Application for a non-material amendment following a grant of planning permission.
Town and Country Planning Act 1990

Use name: **HADRIAN'S GARDEN VILLA**

CHANGE OF USE OF EXISTING SINGLE GARAGE & WORKSHOP TO FORM ADDITIONAL BEDROOMS & BATHROOM IN HOLIDAY LET, INCLUDING CONSTRUCTION OF NEW PORCH

19/01929/FUL

Drawing No 36/8
 Hadrian's Garden Villa
 Kufflers Close
 Horseshaw, Nr Borden Mill
 NE47 7HF
 Existing & fort Proposed Roof
 Plan Scales 1:100, 1:20

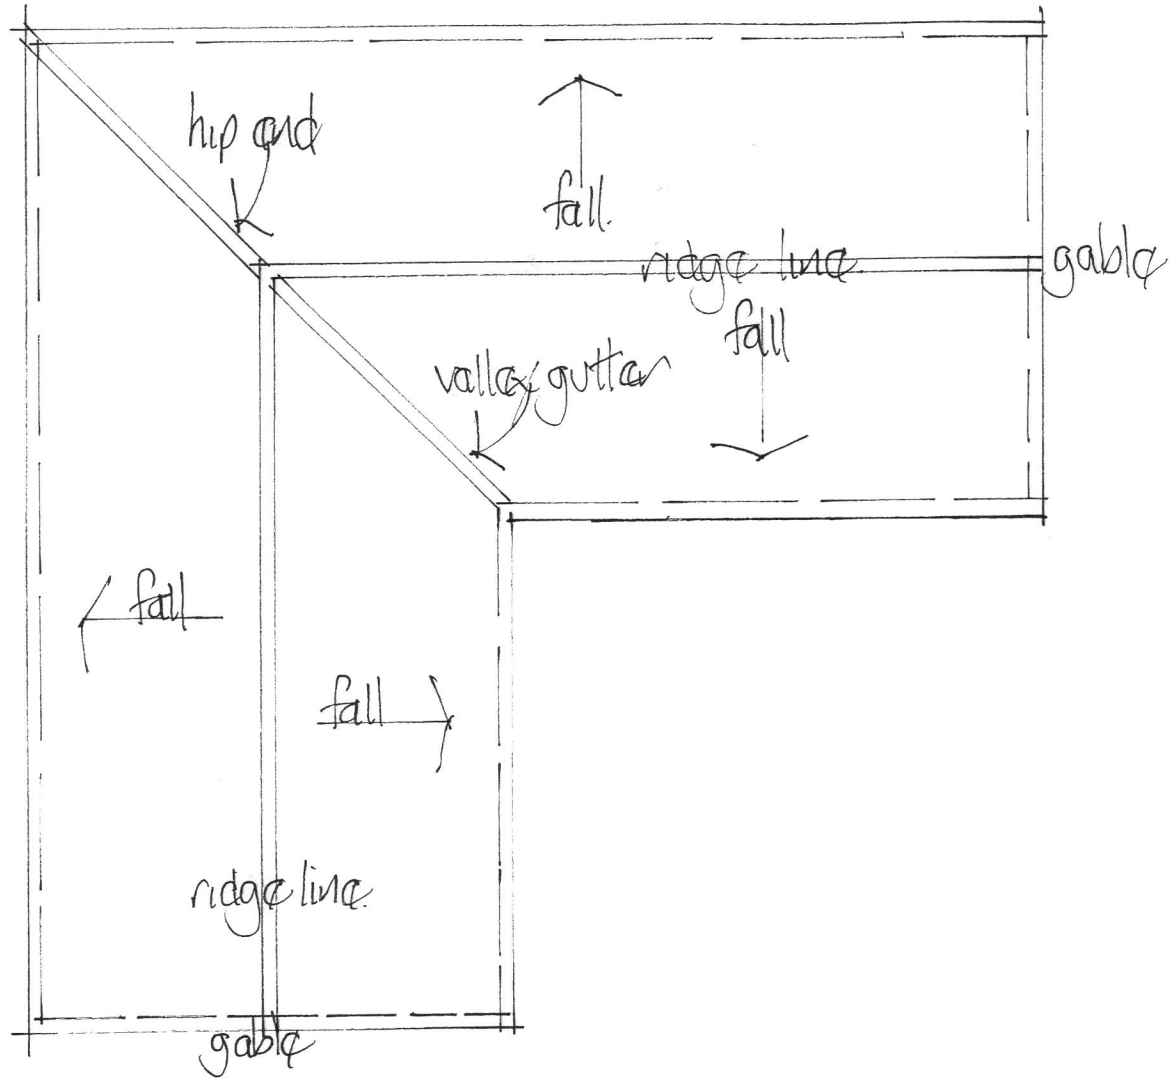
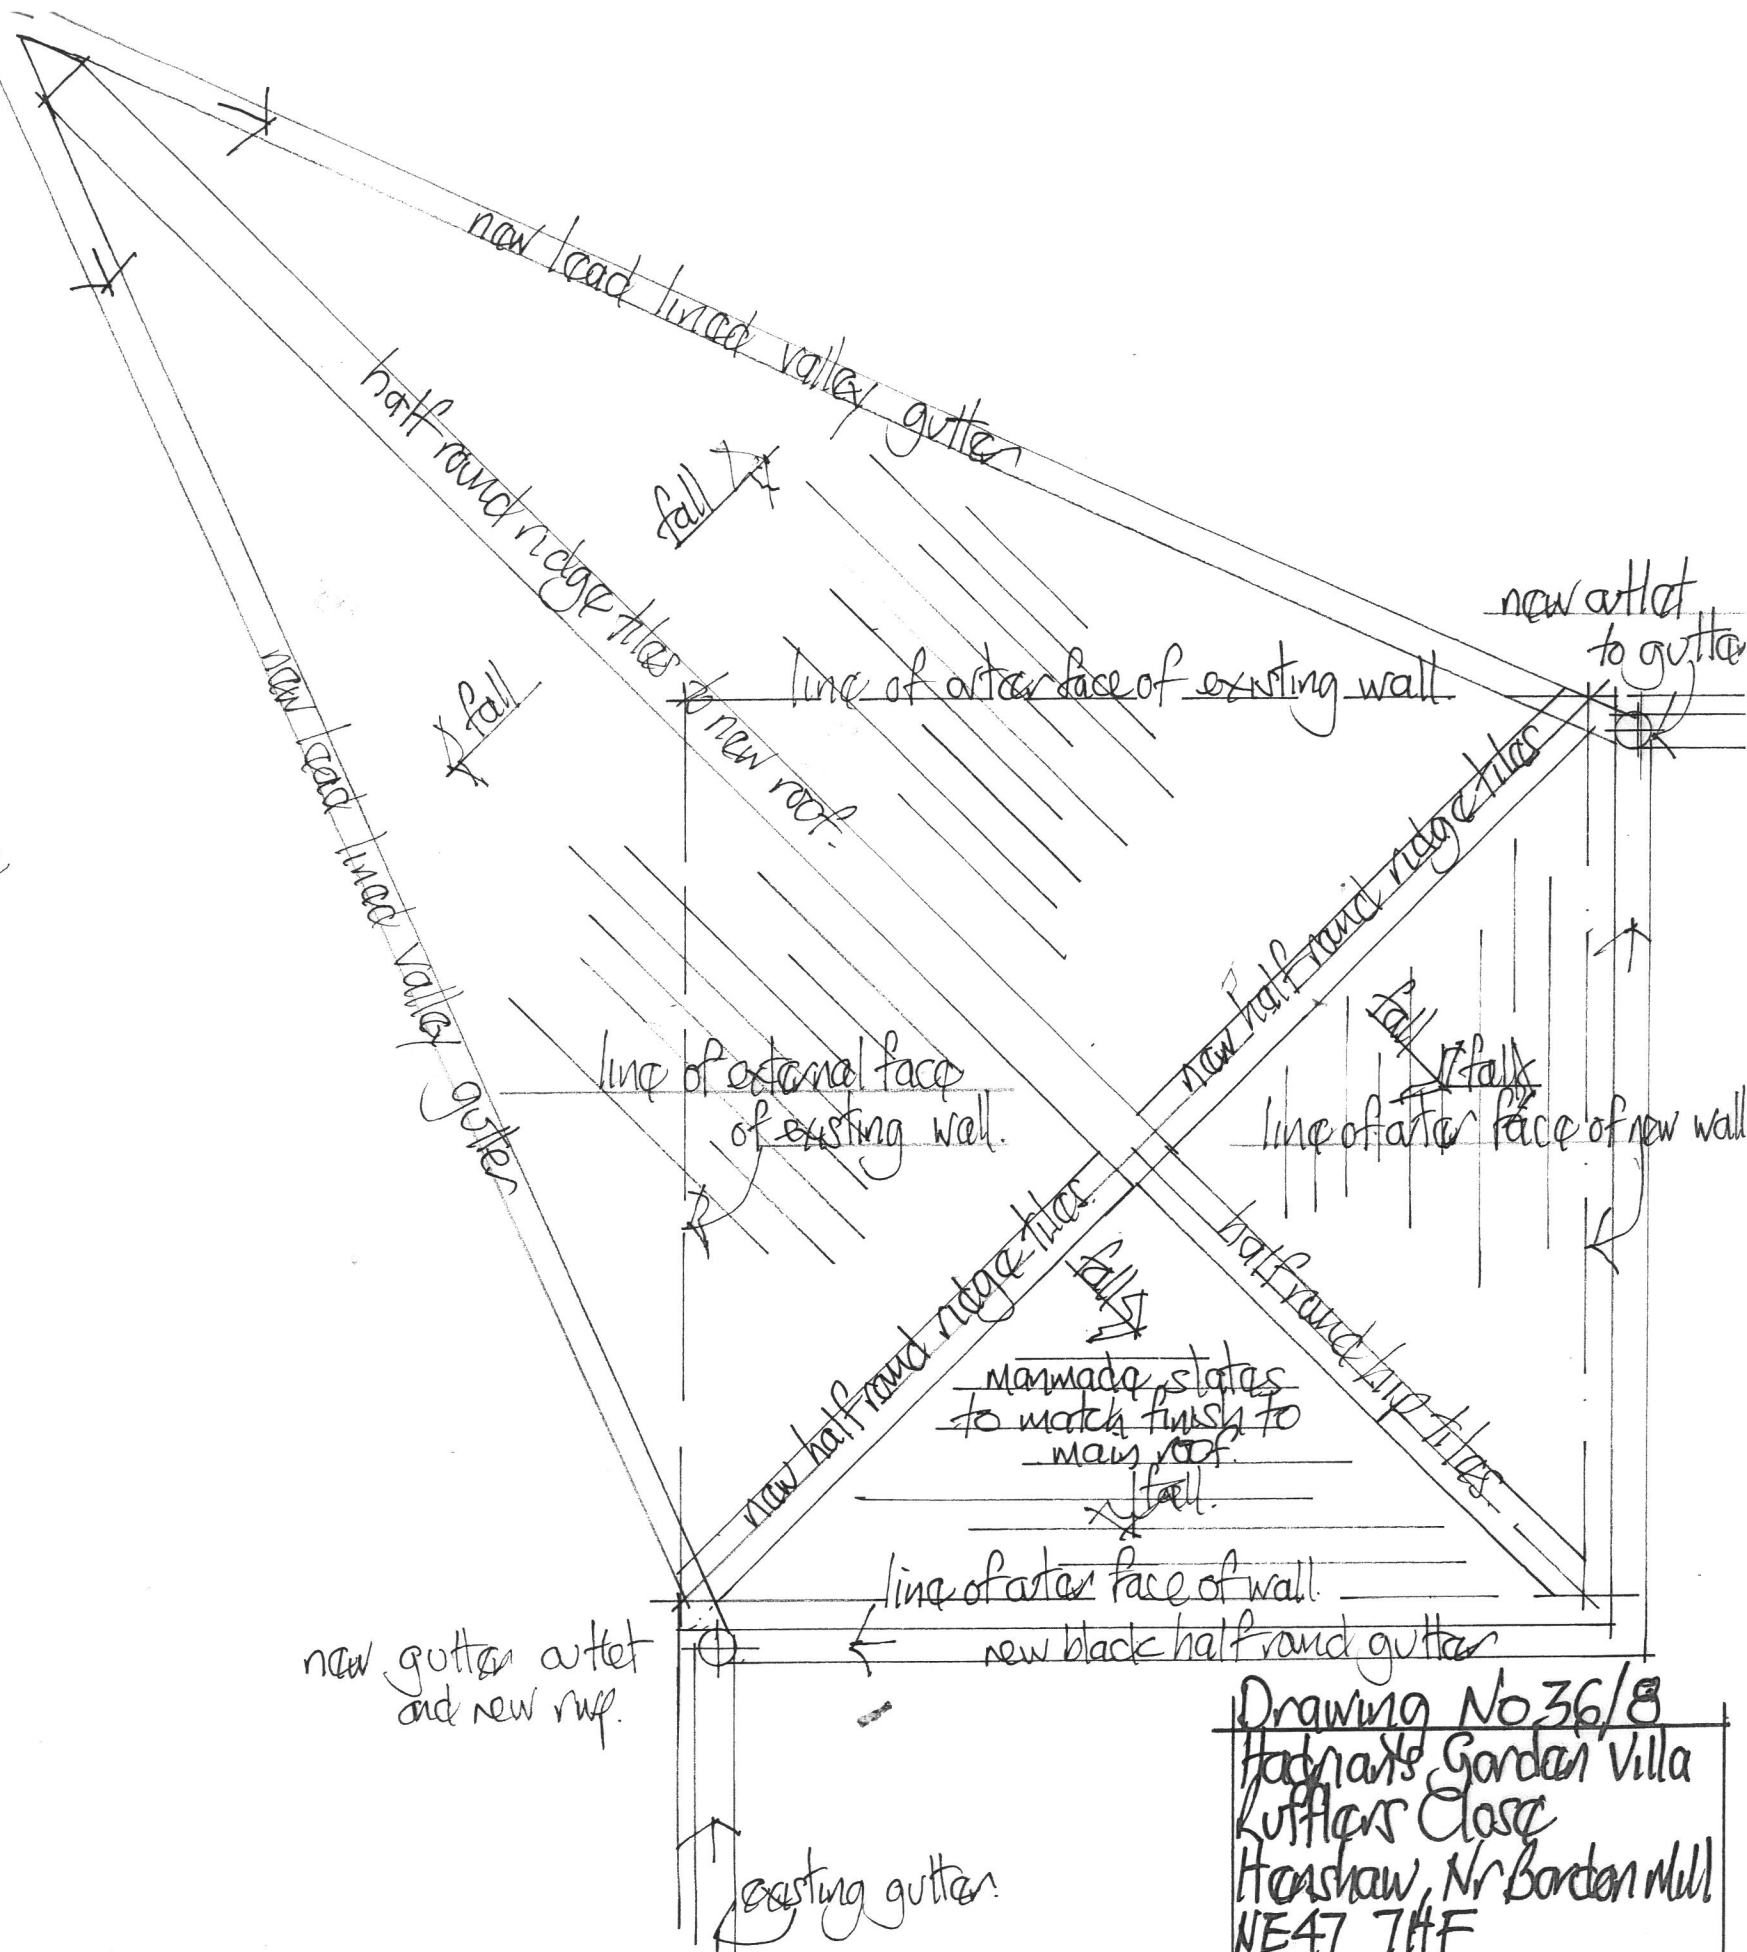
- i) Porch overall size increased from 2.2 x 2.2m to 2.4 x 2.4m.
- ii) Porch roof to have a hipped end instead of gable
- iii) narrow window added to existing shower room.
- iv) Additional window added to west Elevation of Living Room.
- v) windows to new passage and new bathroom reduced in size.
- vi) window to Bedroom 3 to North Gable Elevation reduced by 1/3rd.

- i) Existing shower room does not have any natural light or ventilation.
- ii) smaller windows to passage and new bathroom will match porch windows.
- iii) new window to living room will give more light into room from west elevation.
- iv) reduction in window size to North Elevation to Bedroom 3, will be in more in keeping with other window sizes.
- v) roof to porch would be more pleasing to the eye, with a hipped shape roof rather than a more dominant gable.
